KIRKBURTON PARISH COUNCIL

PLAN NO: 2023/60/93667/E

DETAILS: Outline application for demolition of buildings and erection of residential development (up to 261 dwellings), redevelopment of Lodge Cottage for residential use and associated works

LOCATION: Storthes Hall Student Village, Storthes Hall Lane, Kirkburton

Tree Retention Plan - Scale 1:1000

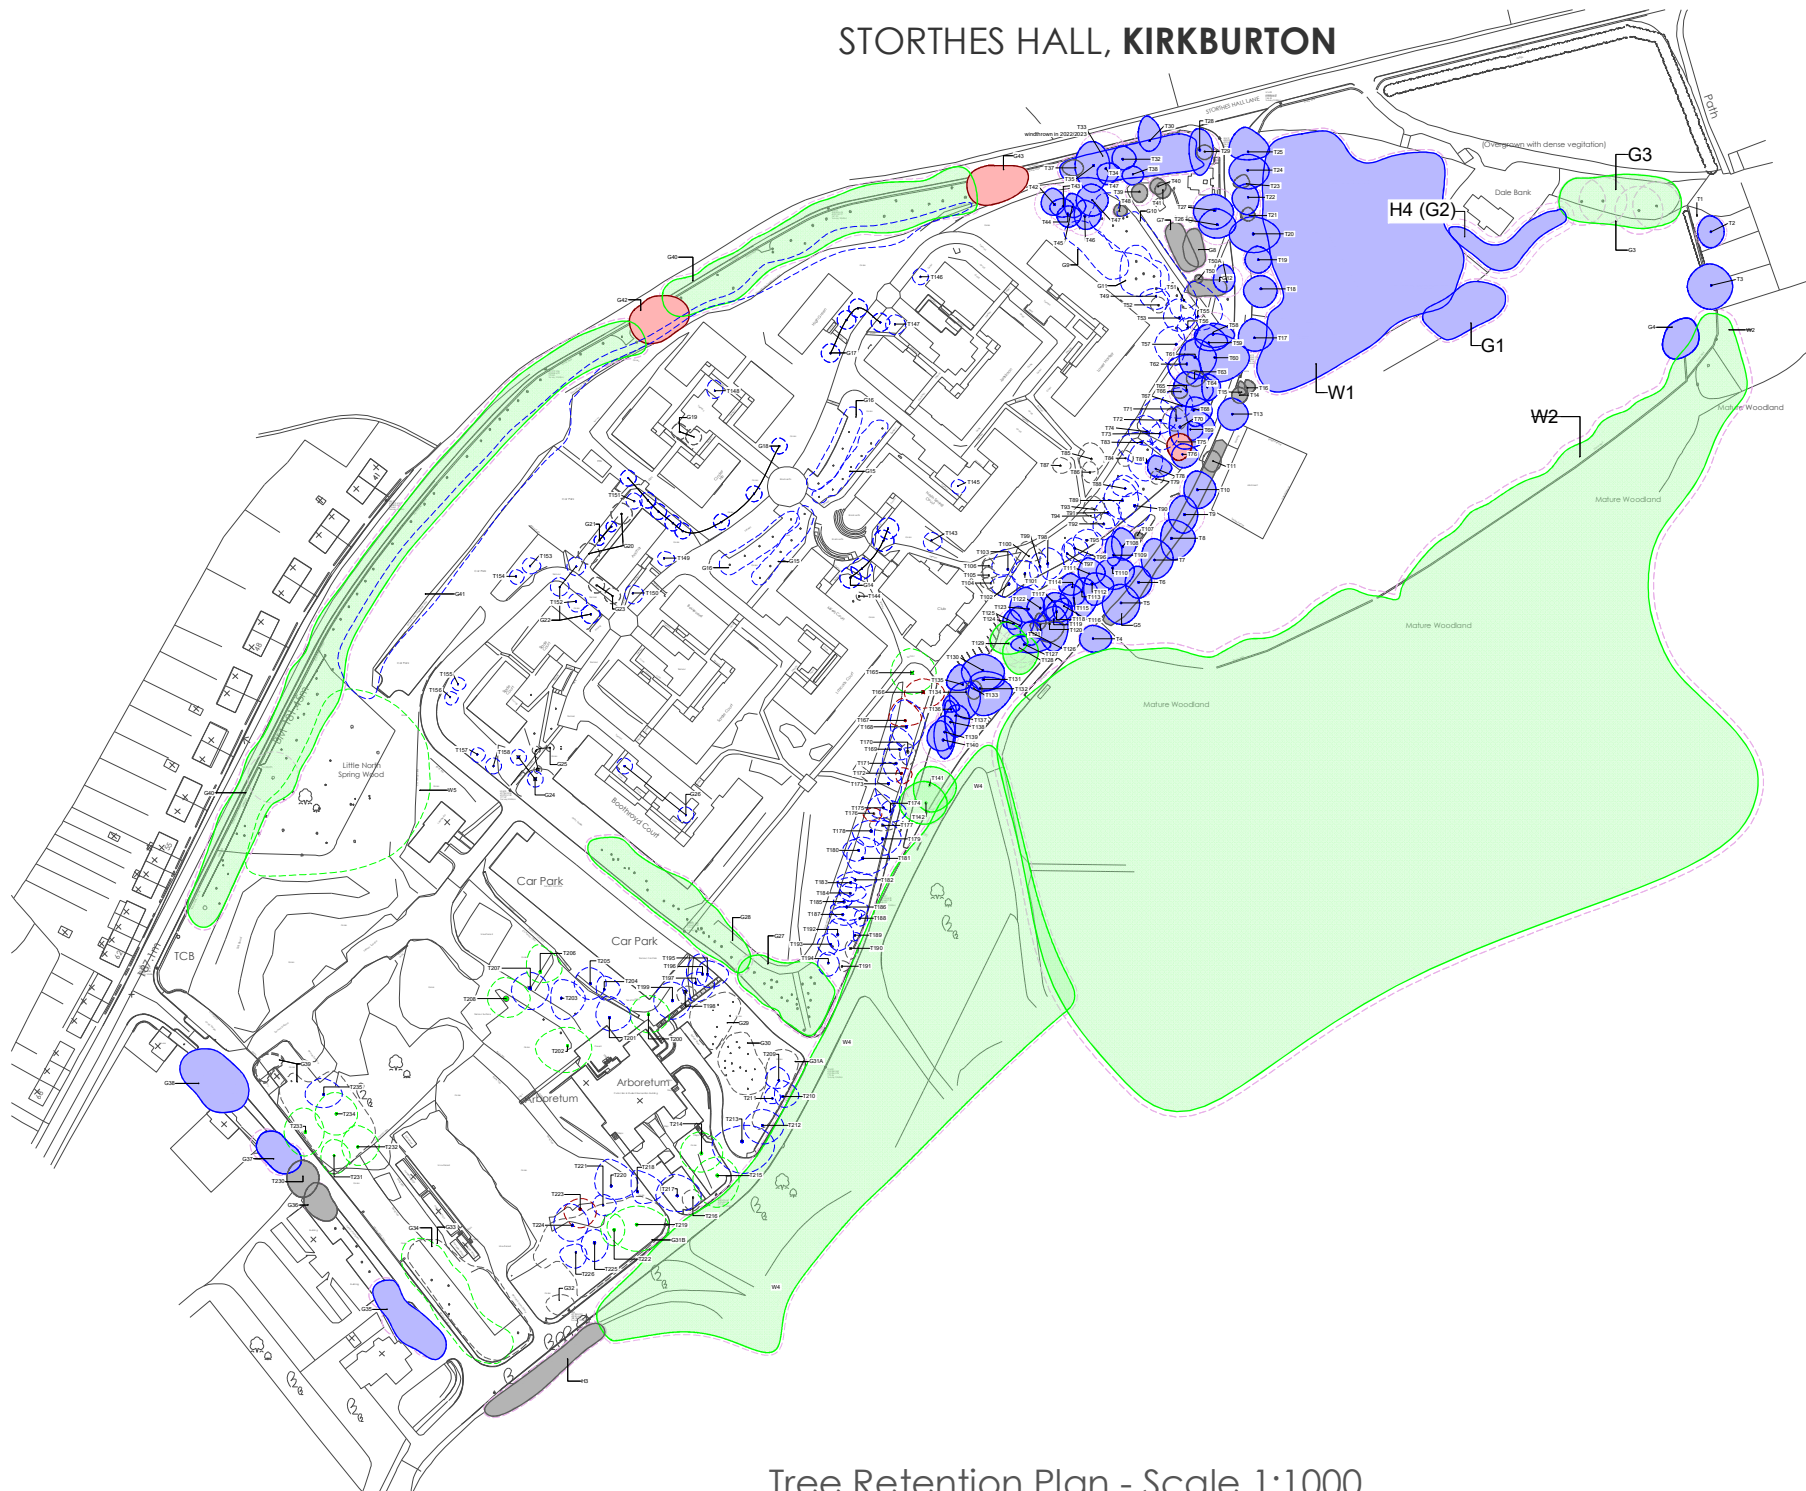
Destruction of Little North Spring Wood and other protected trees: Little North Spring Wood is the largest area of wildlife habitat within the site and is protected by TPO 17/89/w1. The wood is an attractive landscape feature and screens the student village site from the houses opposite on Storthes Hall Lane. The footpath through the wood provides access to the student village site and woodland beyond. The development proposal threatens the destruction of the wood and would also result in the significant loss of other protected trees across the site, most notably those covered by TPOs 17/89/a6 and 17/89/a8, which were retained through the development of the student village.
